# Rampion 2 Wind Farm

## **Statement of Common Ground – Natural England**

**July 2024**

**Rev E**

Graphic A-2 Indicative illustration of vegetation notched to 6m and showing new planting

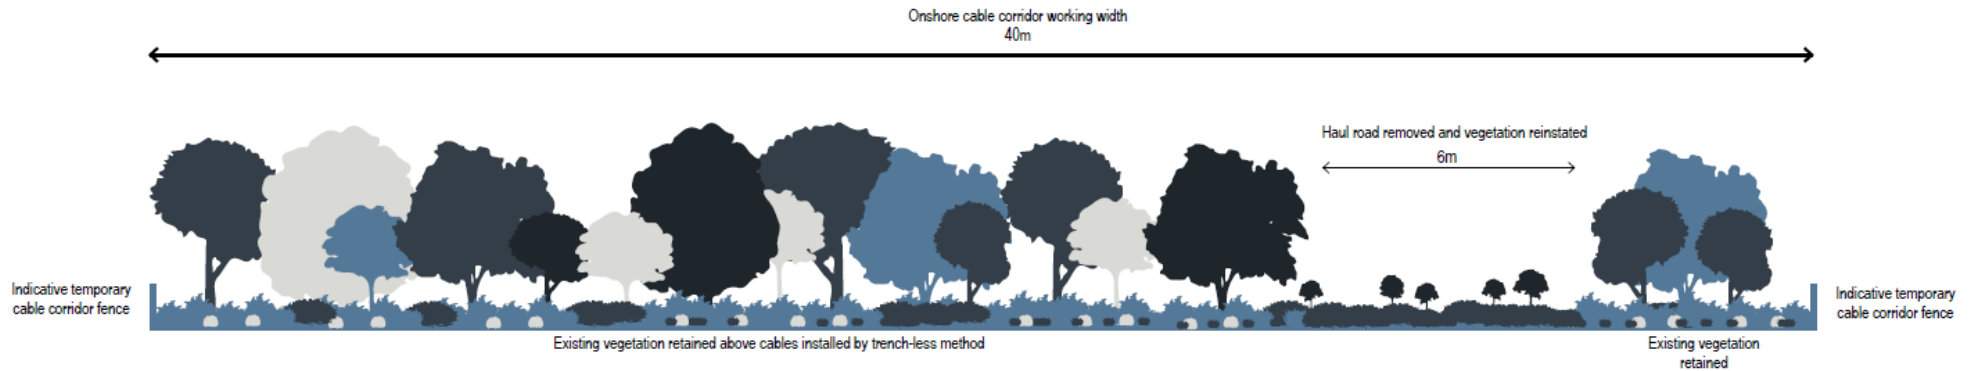
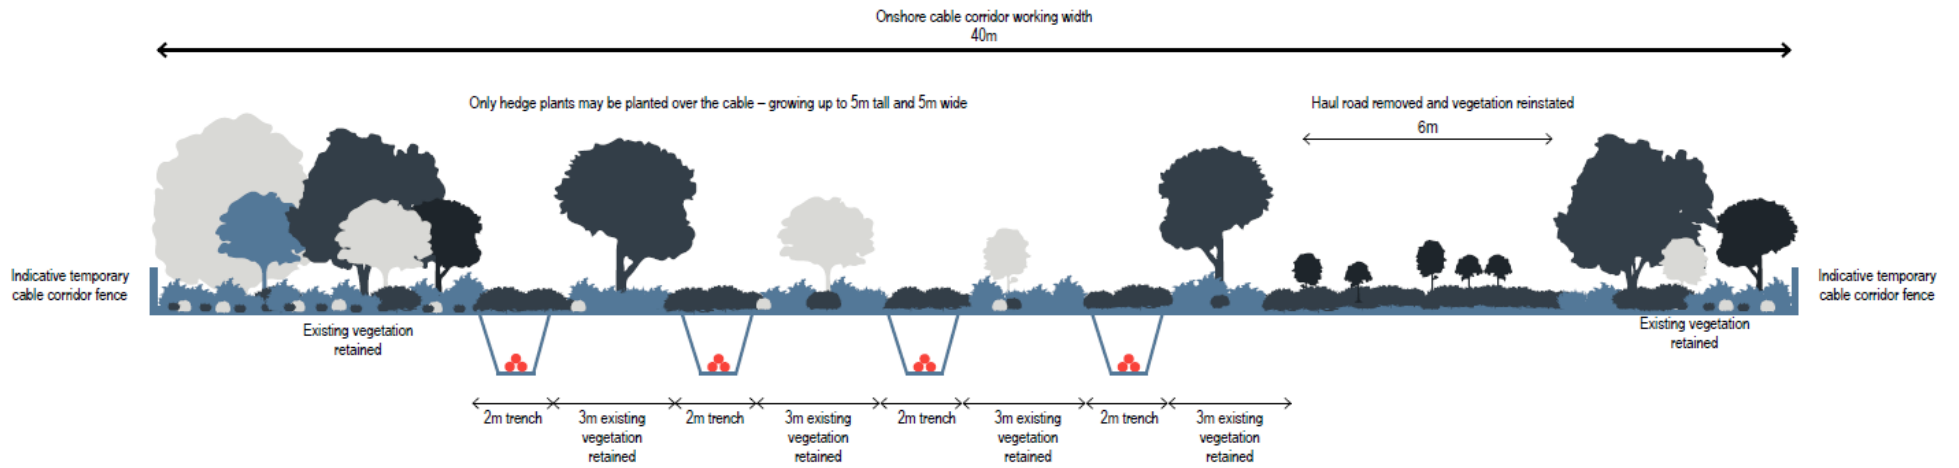
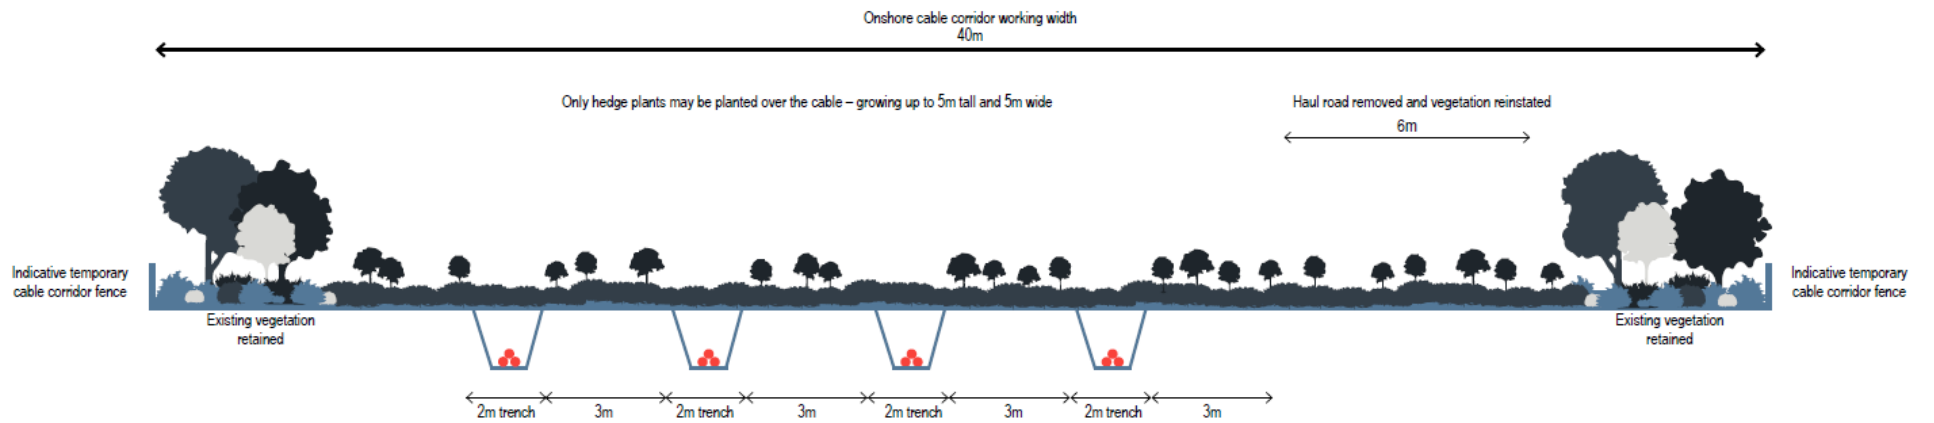
Reference Number	Point of Discussion	Natural England's Position	Applicant's Position	Current Status	Date of Agreement	Record of Progress
NE1	<p><b>This is a Principal Area of Disagreement identified by Natural England.</b></p> <p><b>Concerns regarding adequacy of mitigation proposals for landscape impacts on SDNP due to onshore cable installation</b></p>	<p>The Development will have Significant landscape impacts on SDNP due to onshore cable installation.</p> <p>Natural England advises that due to the substantial lack of credible and detailed evidence in relation to the mitigation proposed, the assessment of effects as set out in the LVIA cannot be relied upon, and that there will be significant residual adverse landscape and visual effects on the SDNP and on its special qualities, setting or integrity.</p> <p><b>Further information needs to be provided to evidence that the proposed mitigation measures are feasible and effective.</b></p>	<p>The Applicant acknowledges that there are some significant LVIA effects on landscape and visual receptors due to onshore cable installation in the Environmental Statement.</p> <p>The mitigation is credible and robust, detail to reassure stakeholders has been added and case studies have been included in response to the request from Natural England and other stakeholders.</p> <p>The LVIA of the SDNP is set out in <b>Appendix 18.3, Volume 4</b> of the ES [APP169]. A number of embedded mitigation measures are listed out in Table 18-25. The LVIA acknowledges that there <i>"will be a significant effect on two of the special qualities and associated setting during the construction phase"</i> and that during construction there will be significant LVIA effects on landscape and visual receptors. The LVIA also concludes that during operation <i>"there will be localised and significant effects on particular landscape elements (trees, woodland and hedges) through Years 1 to 10 reflecting the loss of mature trees, woodland and hedges that cannot be replaced in Year 1."</i> These effects will be partly mitigated through the provision of new, replacement native planting which will be maintained. <i>"These localised effects on individual landscape elements will appear in isolation and will not be sufficient in number, density, pattern or distribution to sustain significant effects on landscape character. There will be no obvious 'linkage' between them due to the reinstatement of the onshore cable corridor."</i> The LVIA concludes that the short duration, reversibility and limited effect on landscape elements (during operation) would not lead to an effect on the integrity of the SDNP.</p> <p>Mitigation relied upon to reduce the residual landscape and visual effects relates to the use of credible and robust techniques, including trenchless crossing techniques (e.g., HDD) and combinations of retaining and reinstating vegetation through construction design, programming, 'notching', and replanting.</p> <p>The <b>Outline Code of Construction Practice [APP-224]</b>, commitment C-115 of the <b>Commitments Register [APP-254]</b> and the assessment in <b>Chapter 22 Terrestrial Ecology and Nature Conservation, Volume 2</b> of the ES [APP-063] therein describe the approach to hedgerow notching. In</p>	<p><b>Not agreed - material impact</b></p>		<p>02/07/24: The progress the Applicant has made in clarifying mitigation and adaptive management measures has been noted by Natural England. However, Natural England continue to hold concerns regarding C-115 and continue to dispute the effectiveness of notching hedgerows. Final confirmation of status will be provided post deadline 5.</p>

Reference Number	Point of Discussion	Natural England's Position	Applicant's Position	Current Status	Date of Agreement	Record of Progress
			<p>response to Relevant Representations the text for C-115 has been amended to ensure it is easier to understand. The removal of short sections of hedgerow to allow the installation of cables and replanting is a typical approach used on the majority of cabling / pipeline projects the only difference is the extent of the gap, which the Applicant has sought to minimise already by considering what is feasible and proportionate for each individual hedgerow crossing. Further information on this is provided in the <a href="#">Outline LEMP, Annex A [APP-232]</a>. The existence of hedgerows planted and established across the SDNP provides evidence that hedgerows can be established in this area and there is no reason to suppose that new hedgerow plants, planted to infill gaps in hedgerows that have been notched would not establish in a similar manner to the existing hedges.</p> <p>The <a href="#">Outline LEMP [APP-232]</a> sets out management and maintenance including replanting should any plants fail. This has been updated with further details confirmed at deadline 3.</p> <p>Hedgerows are 'man-made' elements and often subject to replanting / coppicing / laying / trimming. An actively farmed and rural landscape includes examples of change to hedgerow management and the establishment of new hedgerows as part of its 'working' landscape character – this often varies between landowners and LCAs.</p>
